Re: 1363 Washington Ave

BOLLARD DETAIL 1/2" = 1'-0" **7**

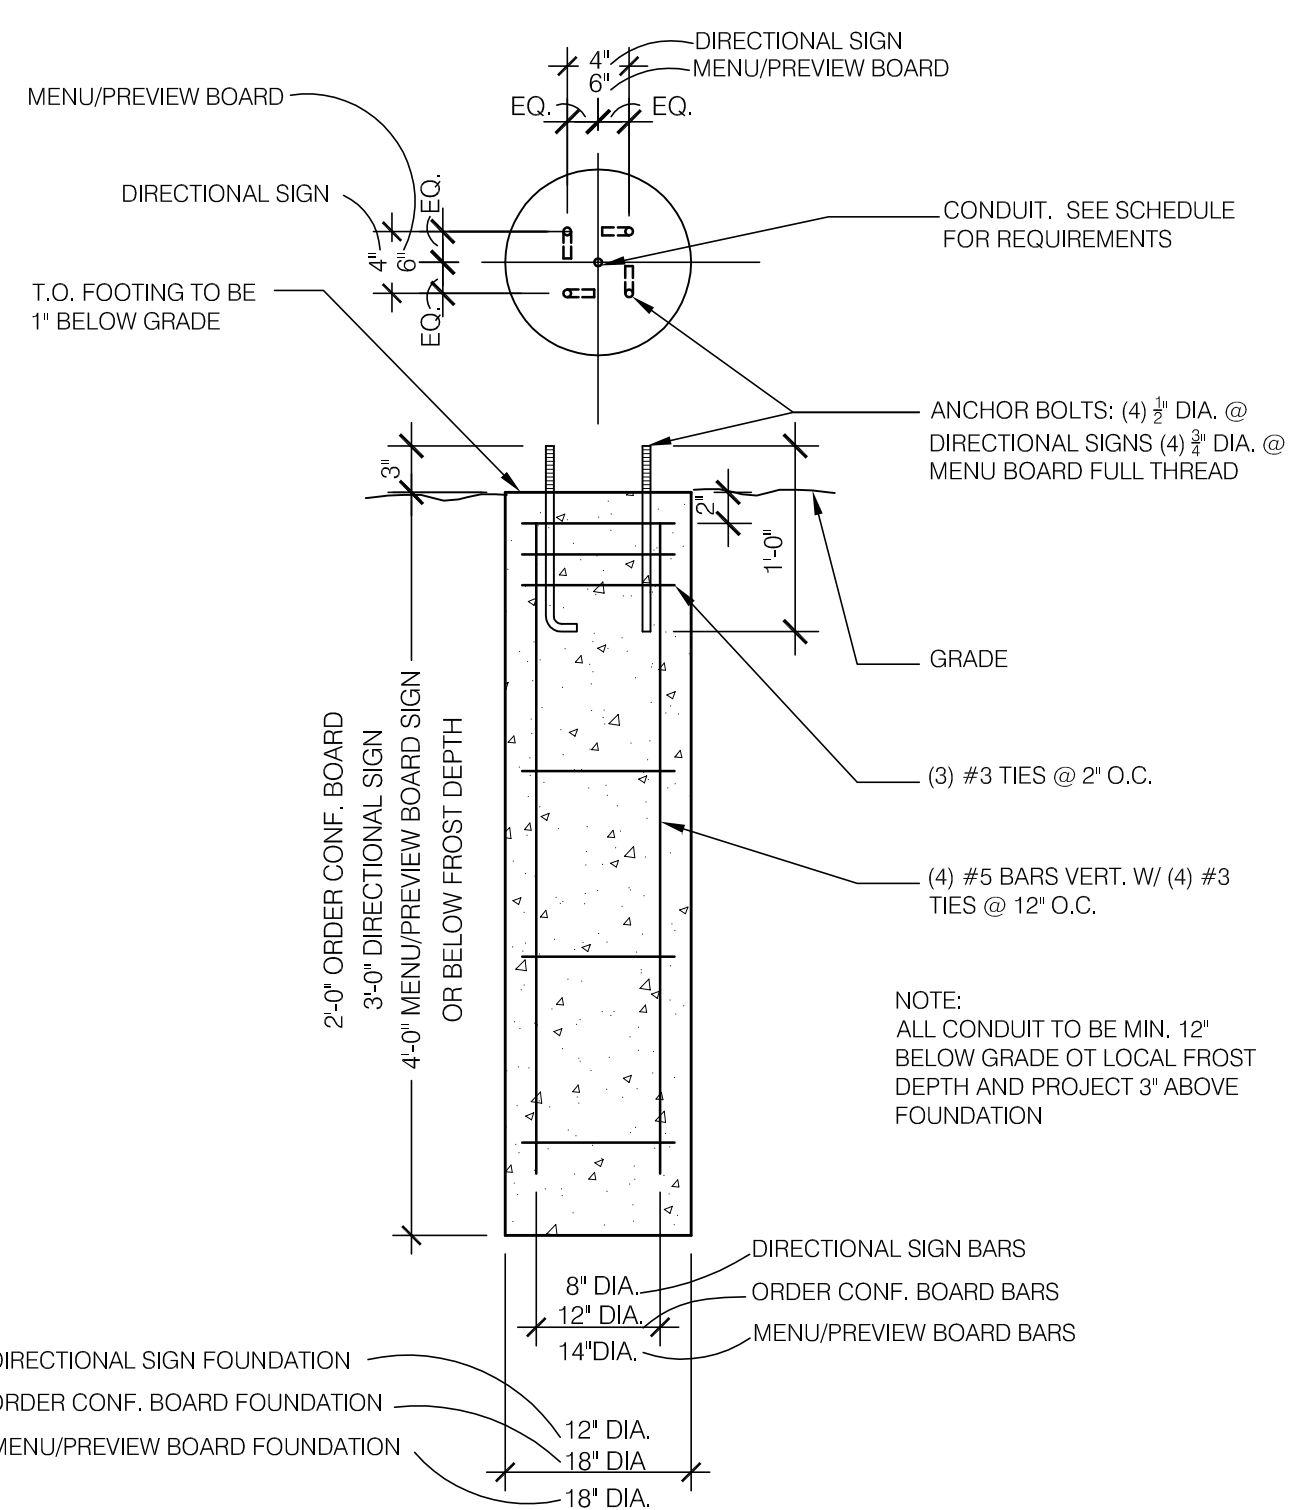
Such paint schemes are unusual here and I don't know how many bollards there will be- this is not a requirement of any kind but relates to the objective that when a site is subject to a site plan we hope to see it improved.

GATE DETAILS N.T.S. **6**

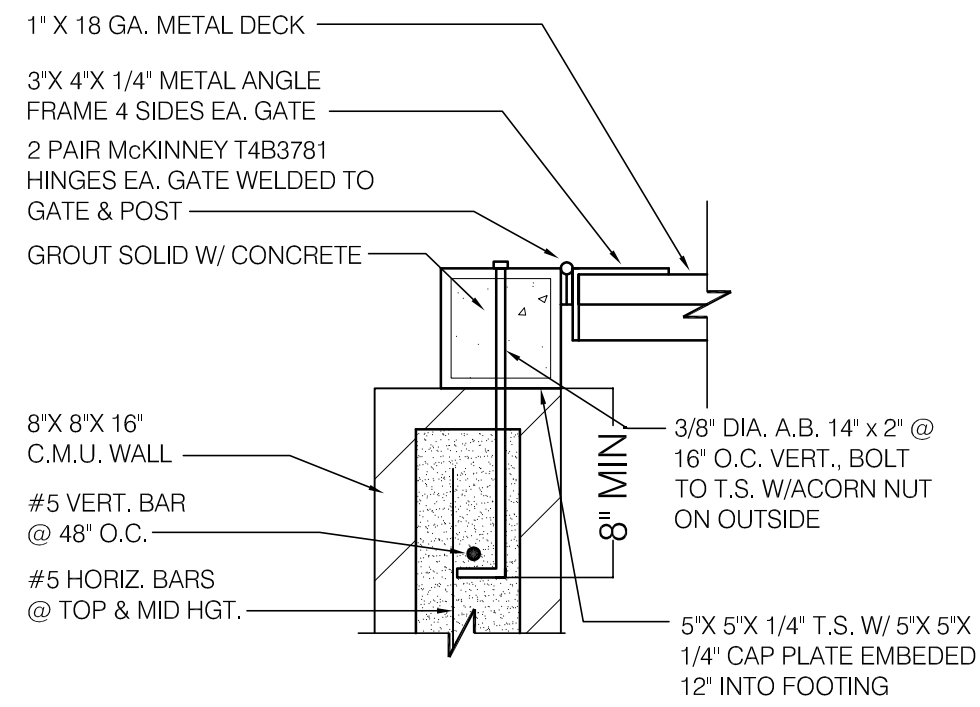
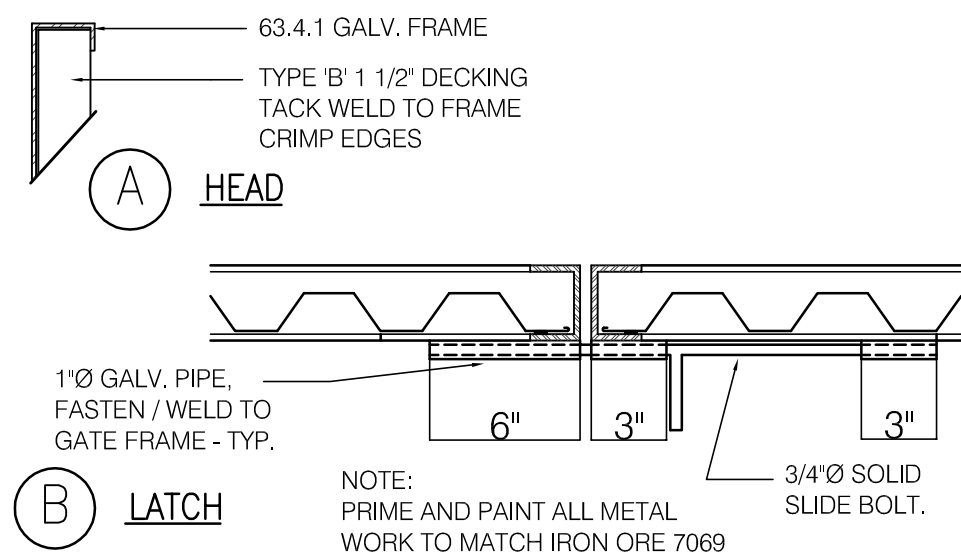
I had not seen any details for the dumpster enclosure until Trent sent along these plans. I have never seen this kind of enclosure proposed in Portland (I have been here 11 years) - usually we see vertical cedar fencing and gates where its part of a site plan (except in industrial areas, where usually farther away from the public eye, where we see chain link fencing with slats.) It needs to be high enough to screen the dumpster inside.

In the continued spirit of trying to work with the City of Portland, I have asked the civil engineer to add a small planting area on the Washington Ave. side of the dumpster enclosure for provide some additional screening although I feel this should have been requested this summer in our landscape review.

I accept that it should have been requested when the Landscape Plan was before us- due to the huge number of projects this year our reviewers have been stretched and sometimes we miss things. This is not a big deal but I appreciate it if this could be added - this is the ordinance regarding dumpster screening:
